The following are comments from Public Health for the Accessory Dwelling Unit application: AU-24-00006 Firl.

Subject: AU-24-00006 Firl - Notice of Application

SITE PLAN

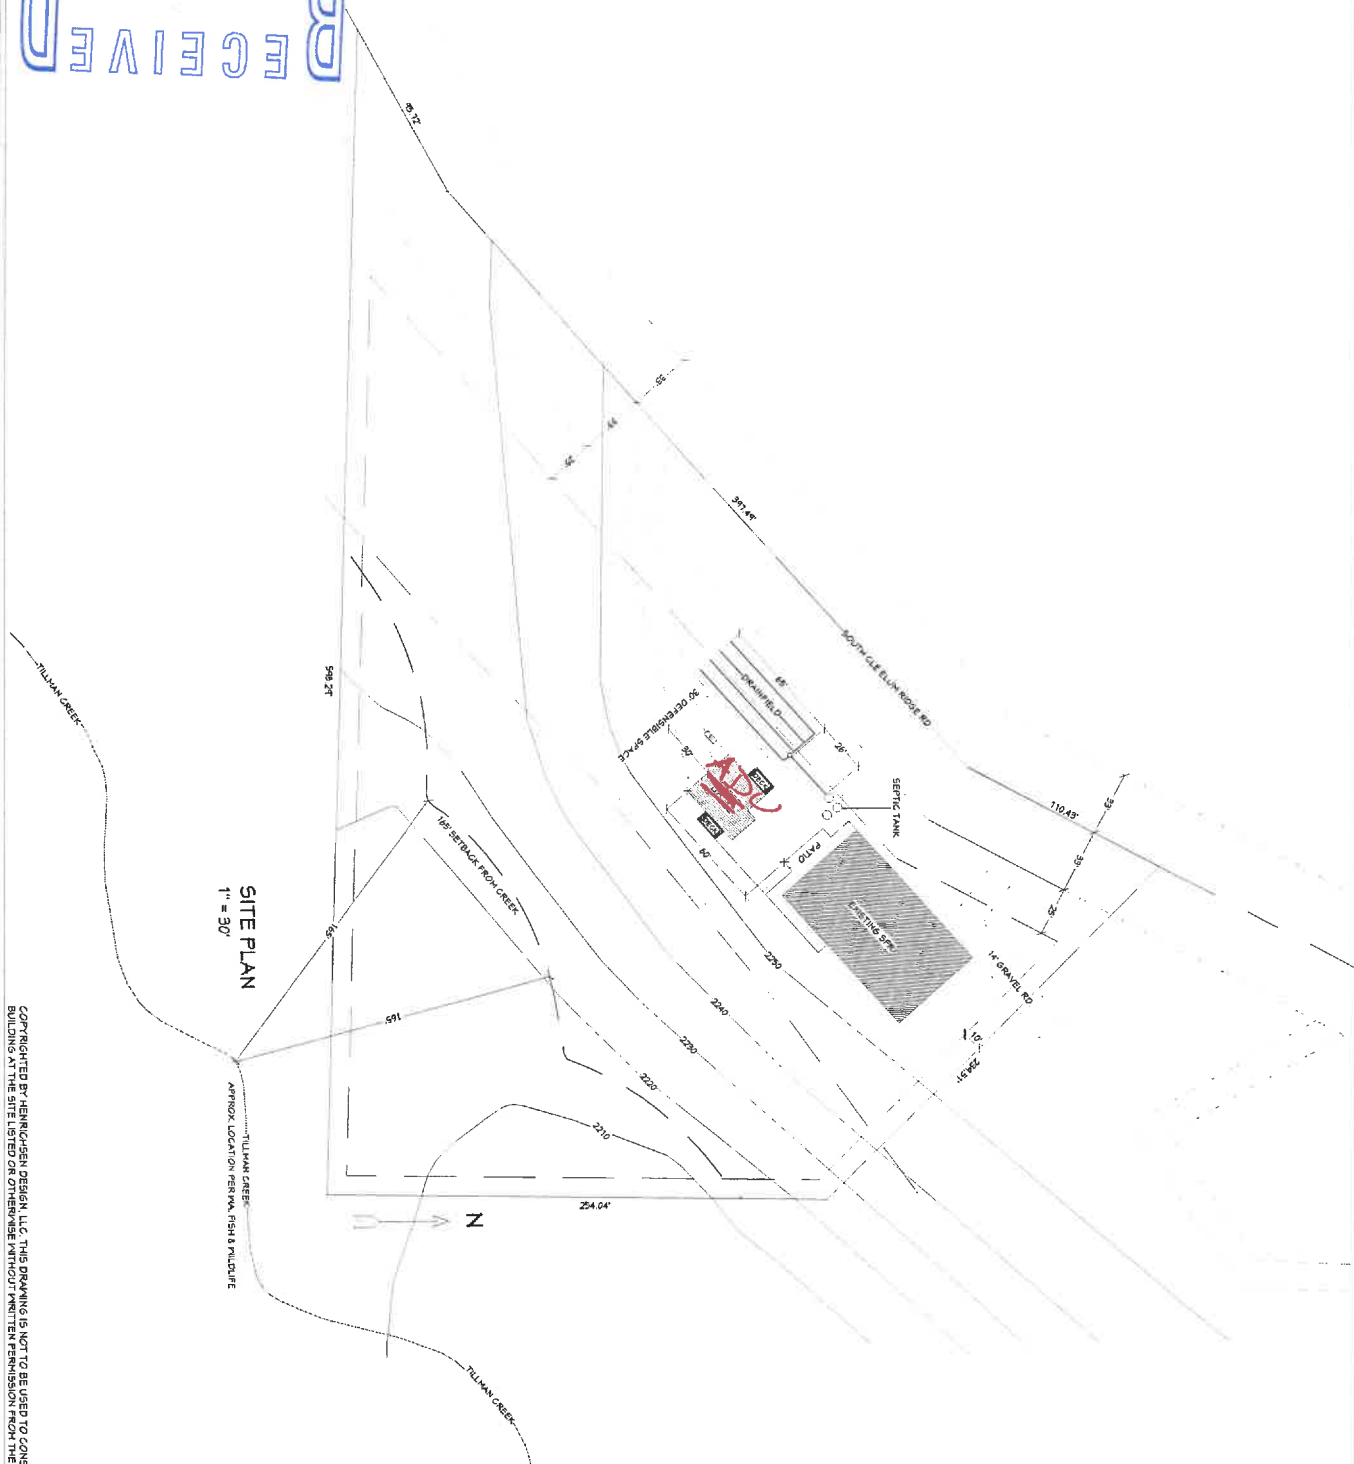
1. The parcel has an existing permitted 4-bedroom OSS, OS-22-00052. The combined bedroom count between the existing residence and the new dwelling unit cannot exceed 4 bedrooms.
2. The parcel has an existing individual well, Well ID Tag No. BND254. Kittitas County Code allows an individual water system that serves two residential dwelling units to be considered a shared water system. The applicants must complete and submit an Adequate Water Supply Determination Form I/S to Kittitas County Public Health.
